Subject: 3/2016/0442

Drawing no. 2147: 02 Revision C

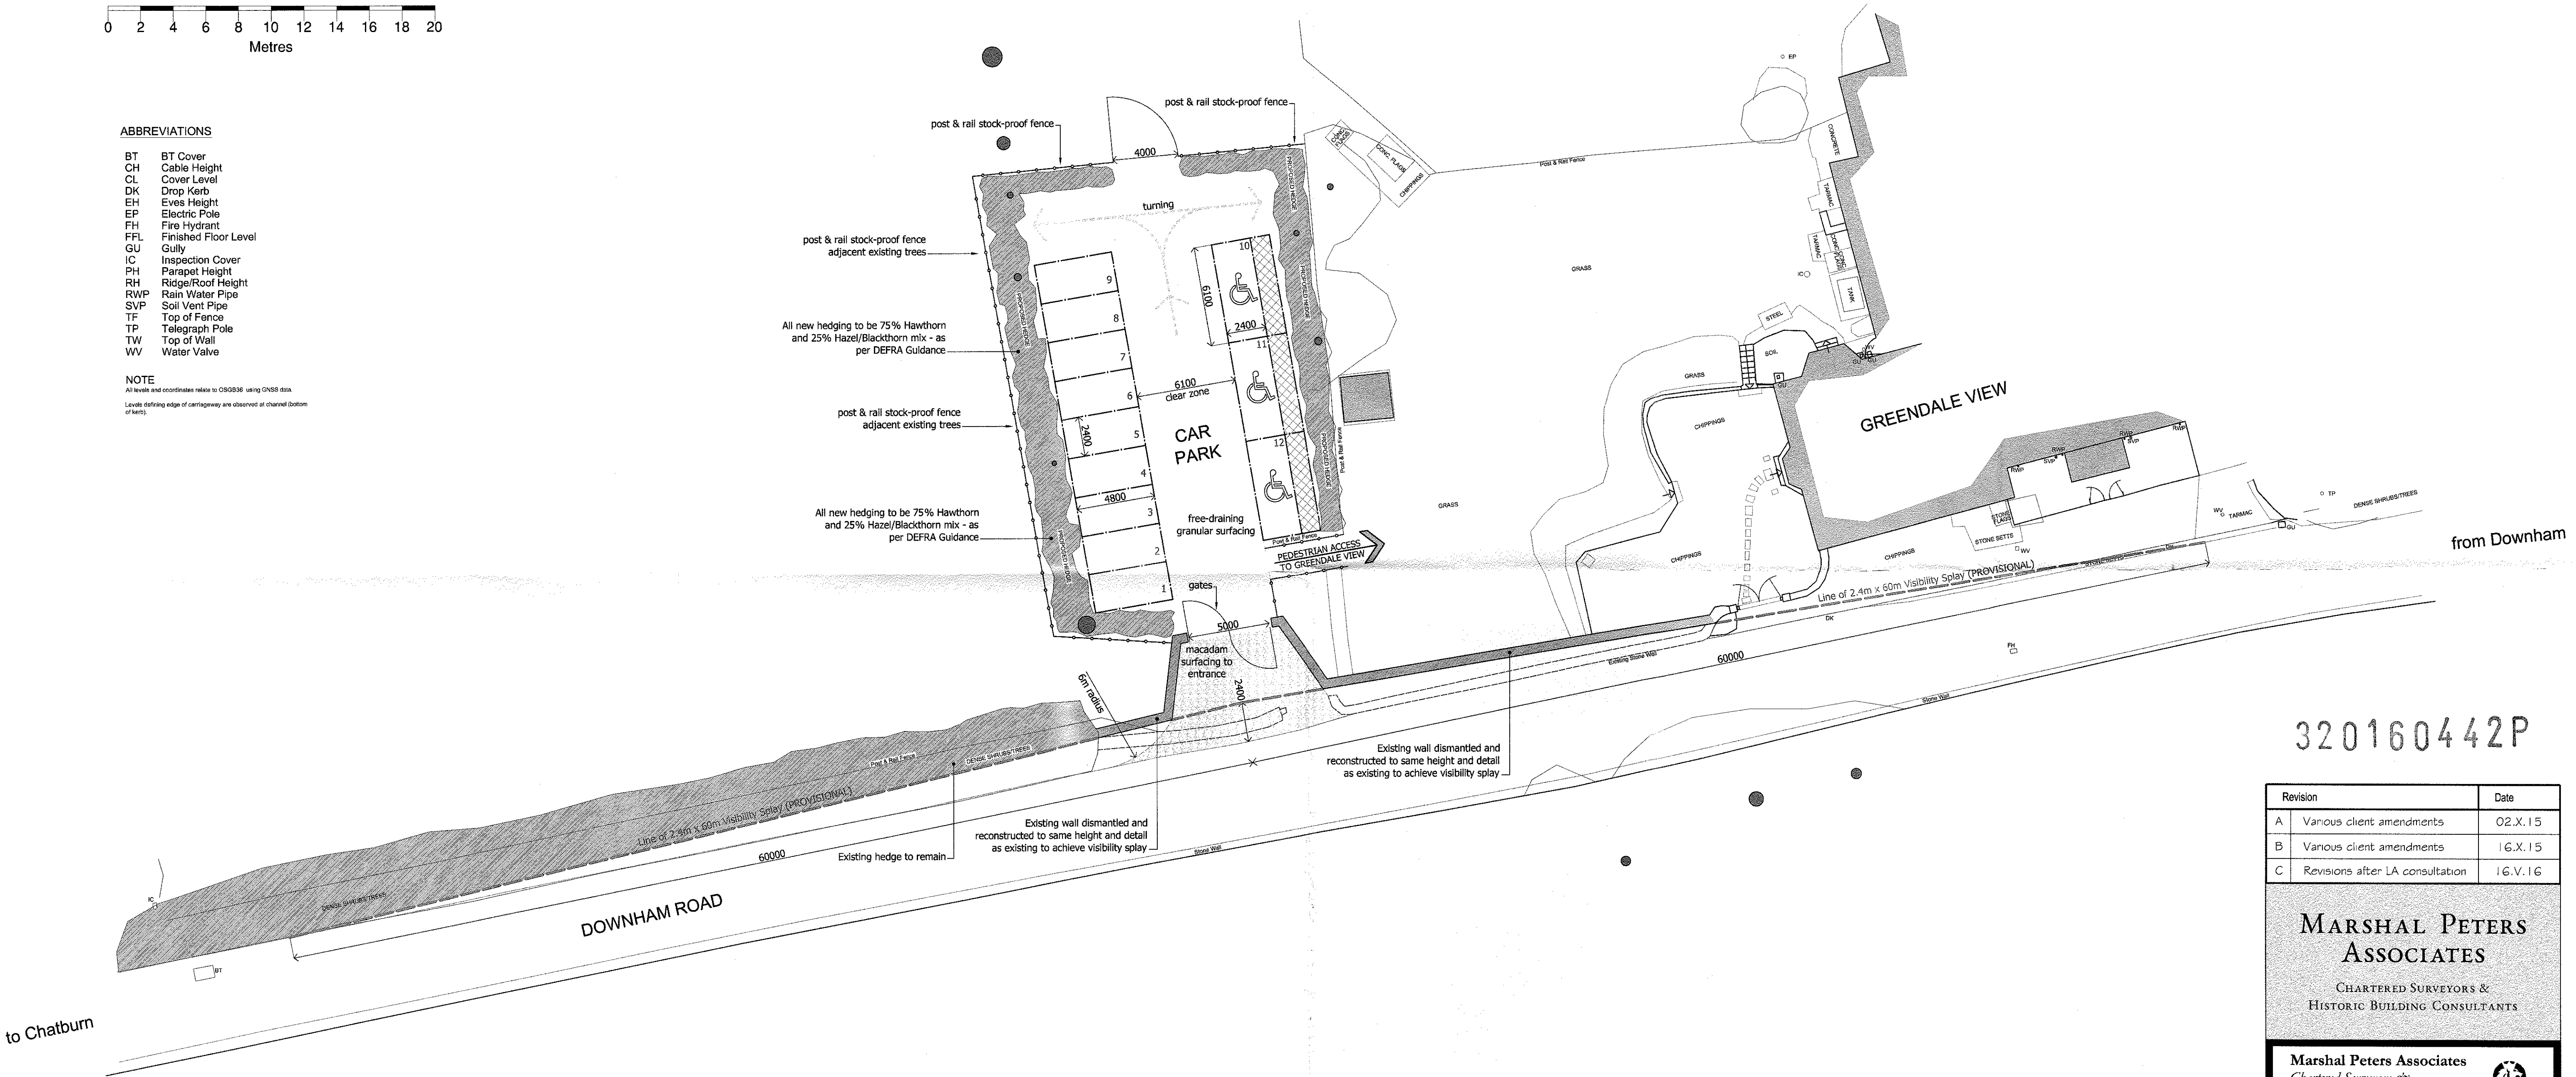
The site survey information for the trees and vegetation is wholly insufficient. Trees within influencing distance and vegetation within the site needs to be considered, surveyed, plotted and categorised prior to any car park design. A mature Lime and a mature Ash within the site (plotted as T1 and T2 on appended map) could be classed as veterans, but unarguably are mature trees with high habitat and aesthetical value. Both need to have a visual tree assessment/condition survey and have a Quantified Tree Risk Assessment (QTRA) carried out.

The QTRA should then be considered alongside the car park proposal (changing the target areas value) to see if the amount of risk is acceptable when the area is occupied with cars. The trees now have a fairly low QTRA score but by changing the target value of the area and taking into account children, adults and cars etc., the trees will become more of a risk to health and safety. Works could be carried out on the trees to reduce the risk to an acceptable level, but the tree works would inevitably leave the trees misshapen and minimise the trees potential e.g. Sustainable Urban Drainage System. (SUDS). Trees do shed limbs as well as deadwood and Lime trees are renowned for high sap content and will always leave resin and debris on cars parked in the vicinity.

Ground compaction is another factor within this development. The Root Protection Area. (RPA) within British Standards: 5837 needs to be protected on retained trees. If construction work needs to take place within the RPA of a protected/retained tree, then safe working practices need to be adhered to as can be found within BS: 5837. The root plates would need to be protected from traffic movements and parking.

A detailed tree report containing the information mentioned above is imperative prior to the design and location of the proposed development. As the site stands and taking into account the 'Proposed Car Parking Map', it seems an unsuitable location for a car park due to the negative affect the building and usage of the car park would have on the veteran trees on site and the impact on the overall vista within the AONB.
